Gatwick Airport Northern Runway Project

Appendix B – Response on Landscape and Ecology

Application Document Ref: 10.77

| | DRAWING NO. FIGURE 8.6.3 | REVISION Deadline 8 |

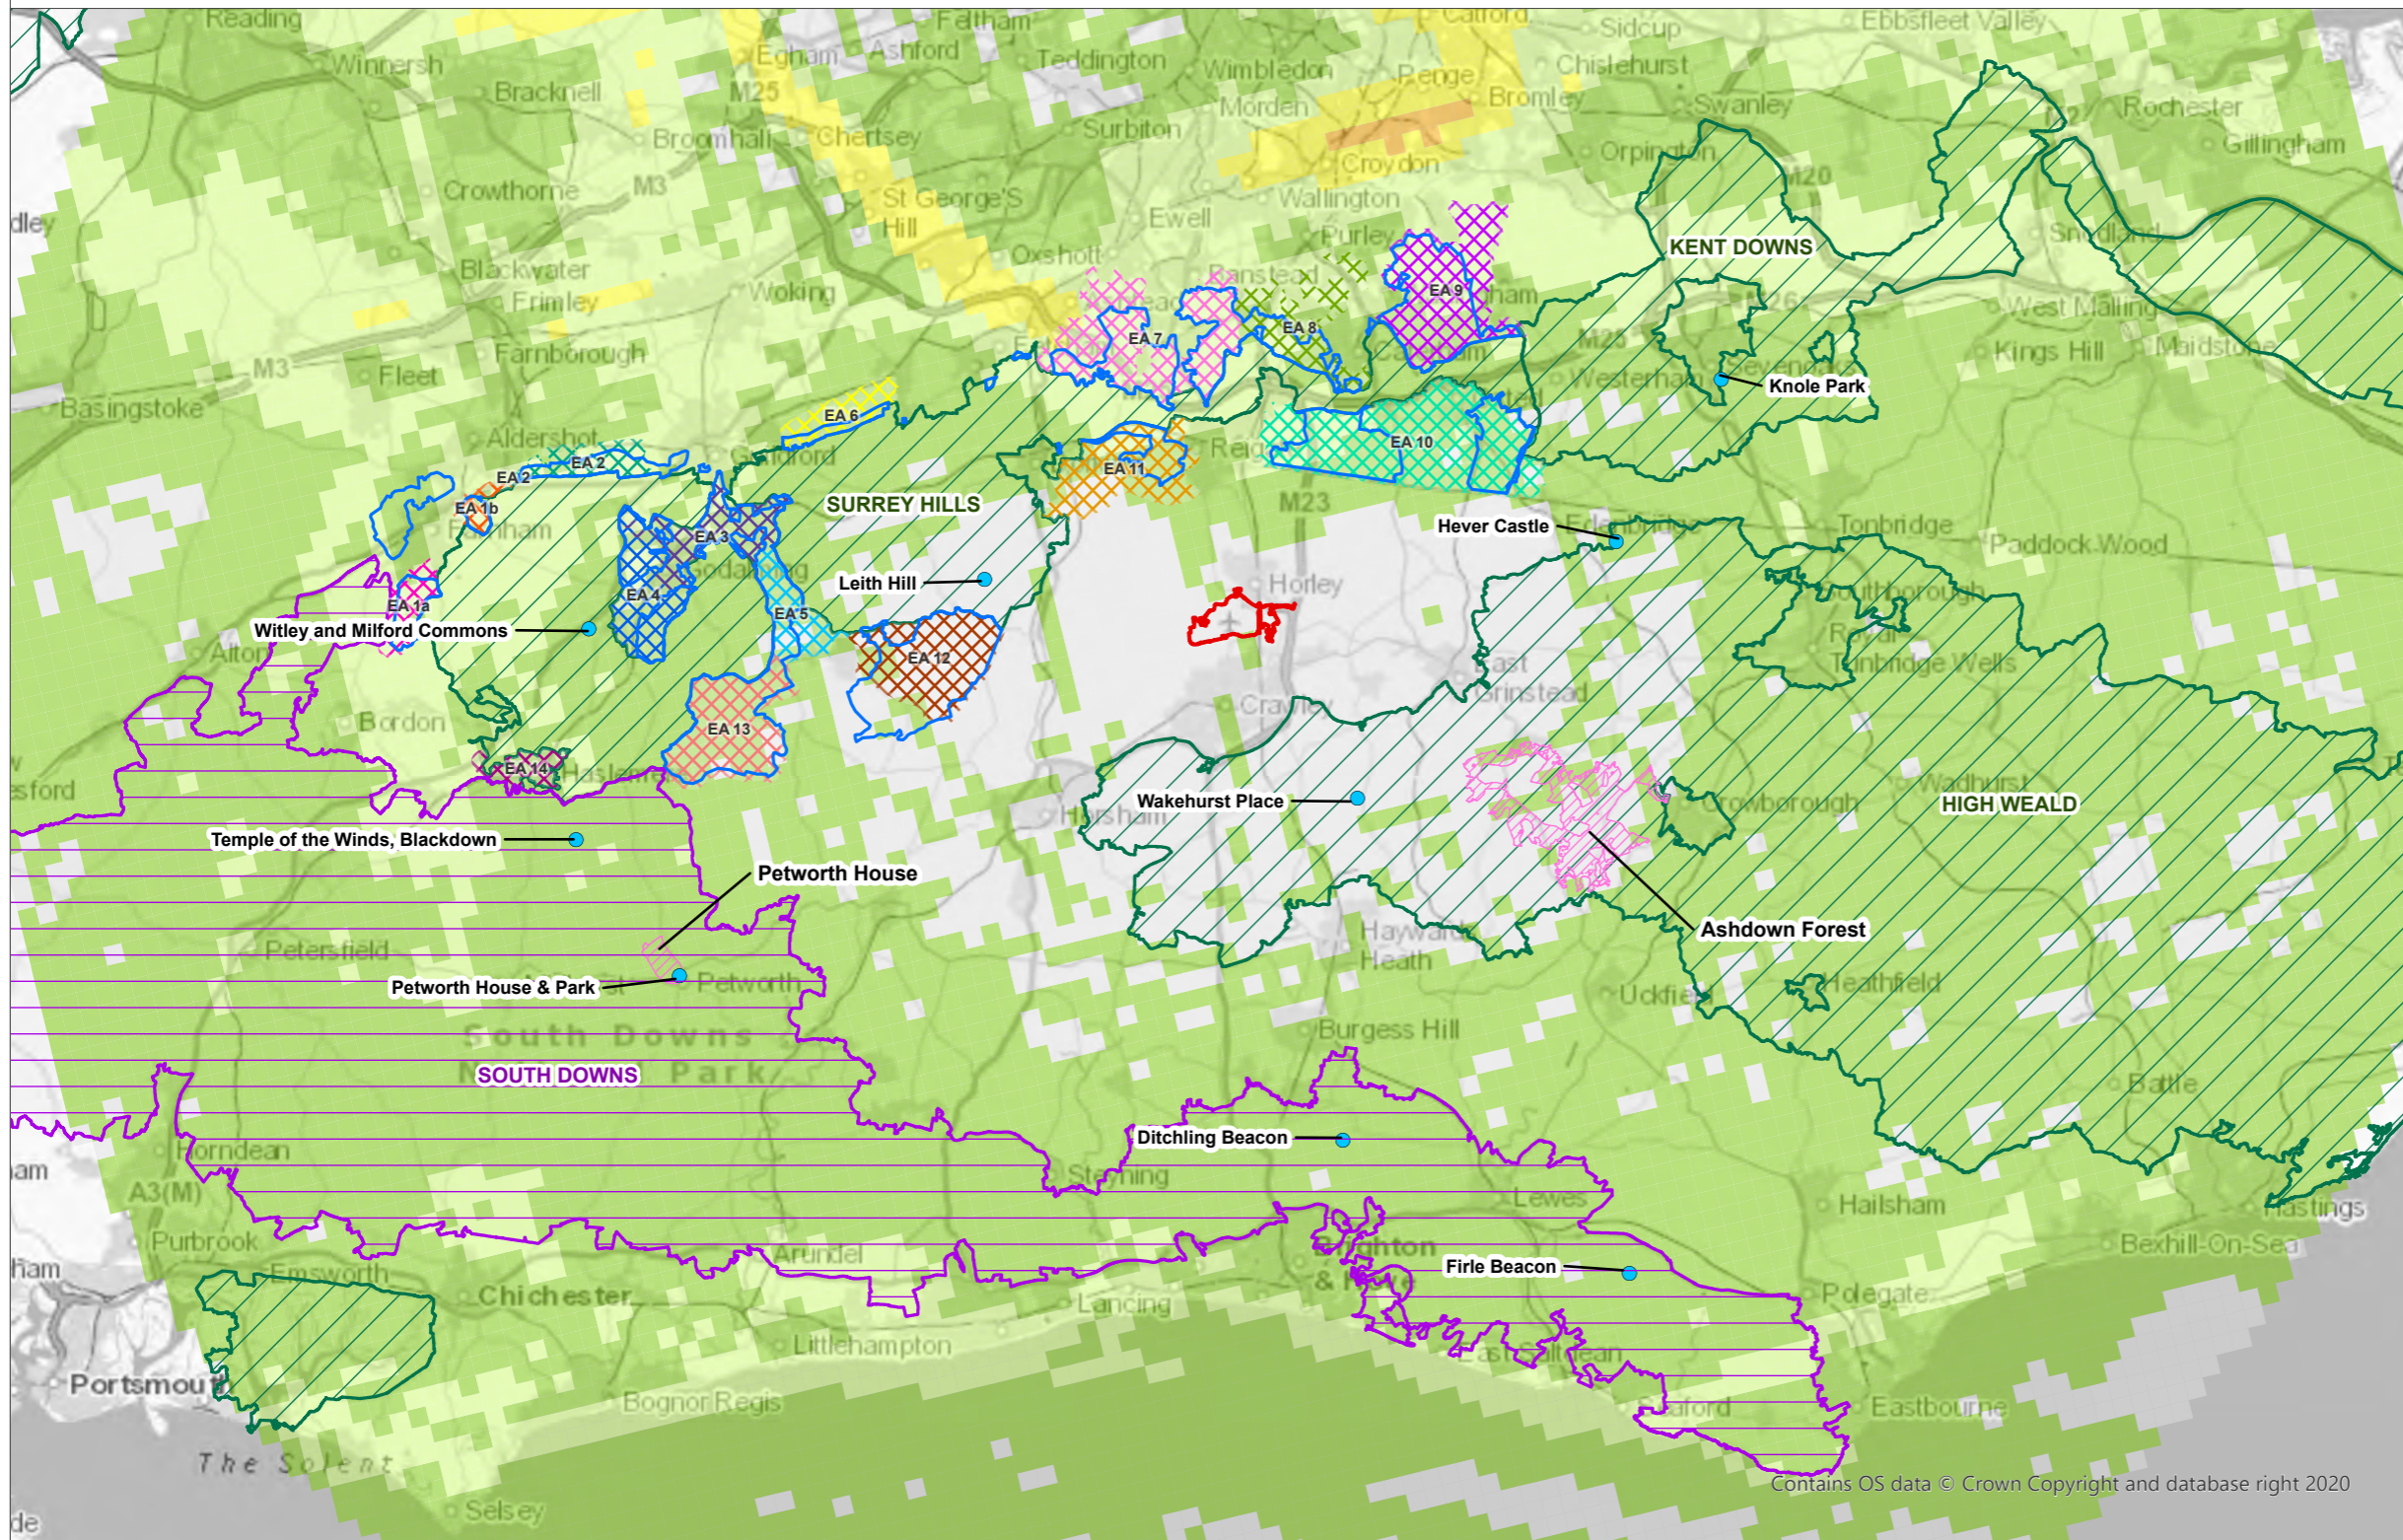
ExQ2	Question to:	ExA's Question:	Mole Valley Response	The Applicant's Response to the Legal Partnership Authorities' Response
Landscape Townscape and Visual Resources				
LV.2.2	Applicant	<p>Surrey Hills National Landscape</p> <p>While noting the answer to ExQ1 LV.1.8 and Appendix B to that answer, please provide further information concerning the likely extent of overflying (in terms of numbers and increase) which may occur over the proposed extended areas of the Surrey Hills National Landscape as a result of the Proposed</p>	<p>MVDC welcome this question to the Applicant. For the benefit of the ExA's knowledge it is understood that an update regarding the boundary review is imminent and will likely provide more information on the proposed boundaries which were consulted on, by Natural England, in 2023.</p> <p>It is accepted that the</p>	<p>The Applicant's response to ExQ2, LV.2.2 [REP7-087] sets out the additional survey work undertaken and the updating of ES Figures 8.6.3 to 8.6.7 with Surrey Hills NL Evaluation Areas. The response includes an assessment of the likely effects on the perception of tranquillity within the Evaluation Areas. No significant effects are anticipated.</p>

<p>Development</p>	<p>timetables for both the boundary review and the DCO are different. However, in the same way that planning applications and some draft future land allocations are considered in the DCO process with the view of attempting to prevent unacceptable overflying and impacts, the draft boundaries of the Surrey Hills expansion should also provide a guide to the NRP application with the appropriate weight attached.</p> <p>Adding to this is uncertainty on how the Applicant has accounted for the boundary review as there is no mention of it within the draft Statements of Common Ground (REP6-062) between the Applicant and NE. While there is existing</p>	
--	--	--------------------	---	--

<p>wording (2.14.3.1) to confirm that increase in overflights of existing NL will not be unacceptable, this does not exist for the proposals of the boundary review. The Council wishes to see similar wording regarding the newly proposed areas to demonstrate due diligence and that this has been discussed and agreed with NE.</p> <p>It is requested that the SoCG be updated and/or the Applicant undertake the necessary assessment of possible impacts</p>	
--	--	--	---	--
